From: Amanda Scholes on behalf of Planning.Responses
Sent: 12 March 2014 12:03
To: Planning Scanning; Amanda Scholes
Subject: FW: Planning Consultation on: LU/30/14/
Attachments: Kitchen Ventilation Planning Guidance.doc

From: Graham Evans
Sent: 12 March 2014 11:54
To: Planning.Responses
Cc: Geoff Bond
Subject: FW: Planning Consultation on: LU/30/14/

Registered: 21st February
2014
Site Address: Waterfront 46 Pier Road Littlehampton West Sussex BN17
5LW

Description of Works: Change of use of part of first floor from flat to restaurant. Single storey extension and roof re-modeling to rear - resubmission of LU/350/13

Drawing:
Floor and roof plans

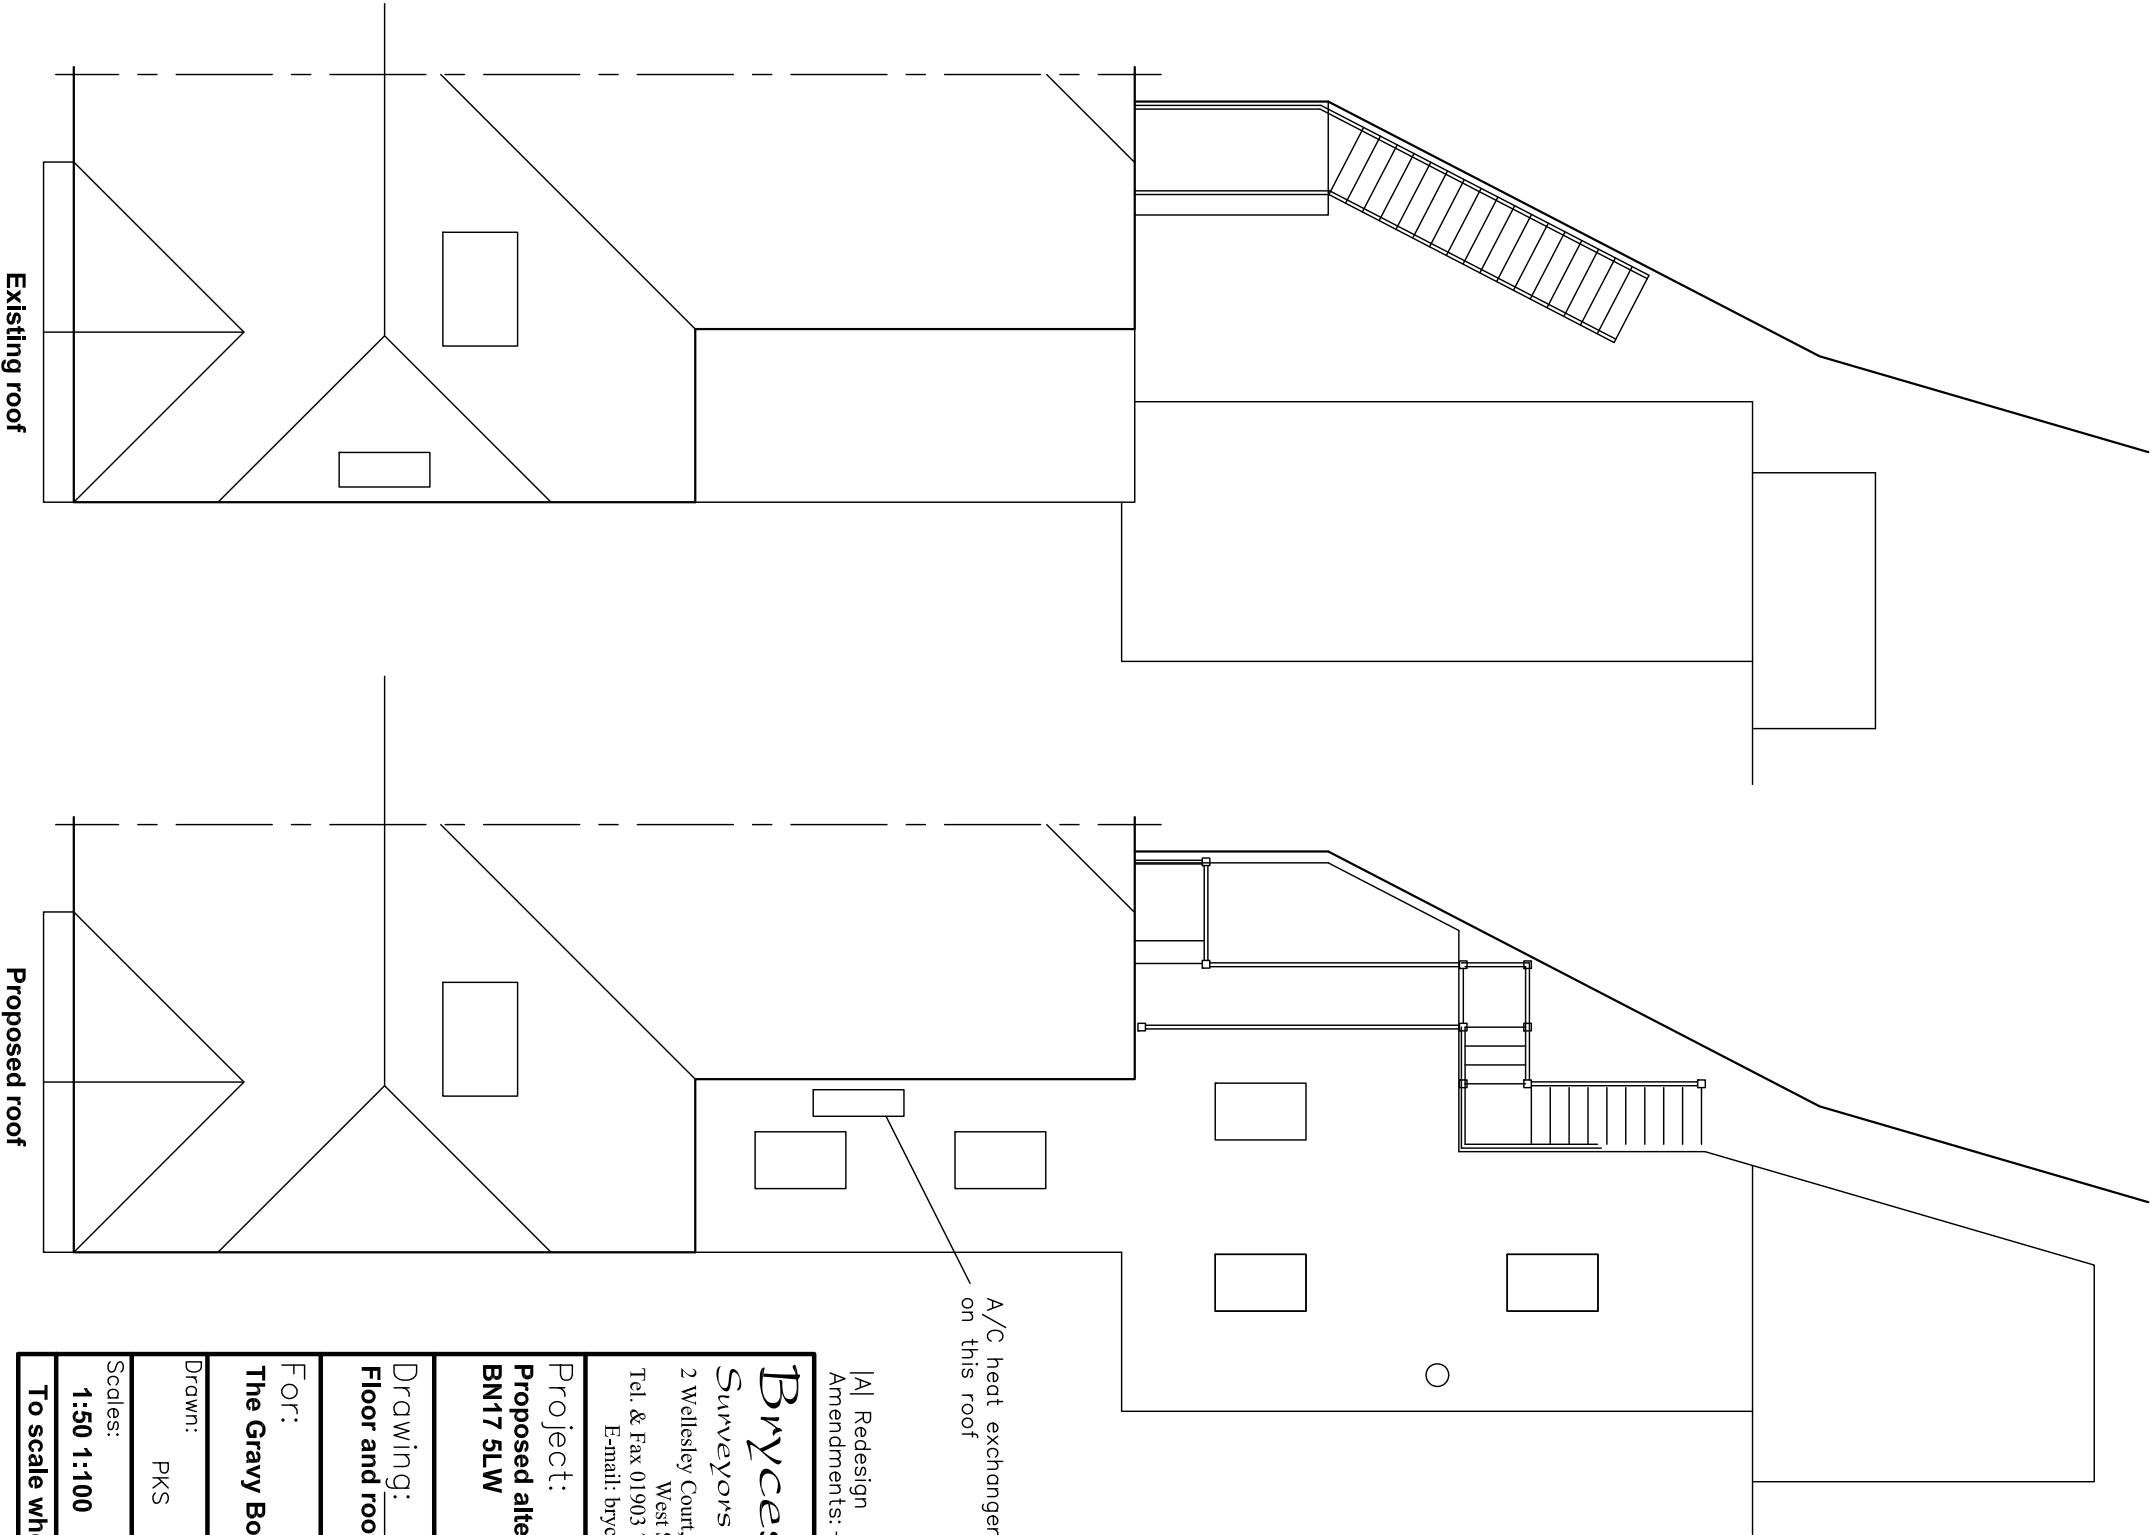
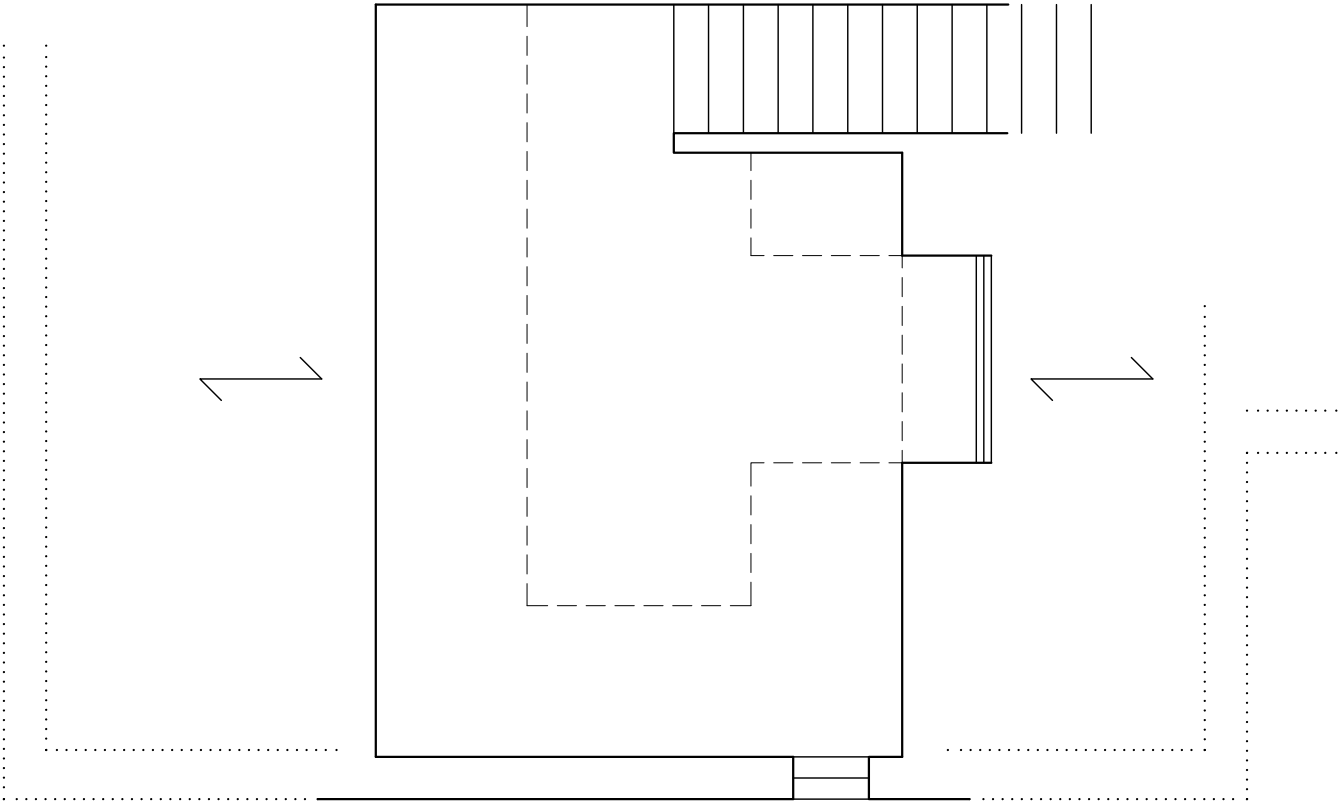
The application also indicates proposed compressor/air handling unit. No information is provided in respect of potential impact of noise on nearby neighbours. In particular hours of use, noise power/sound levels and distance to sensitive receptors.
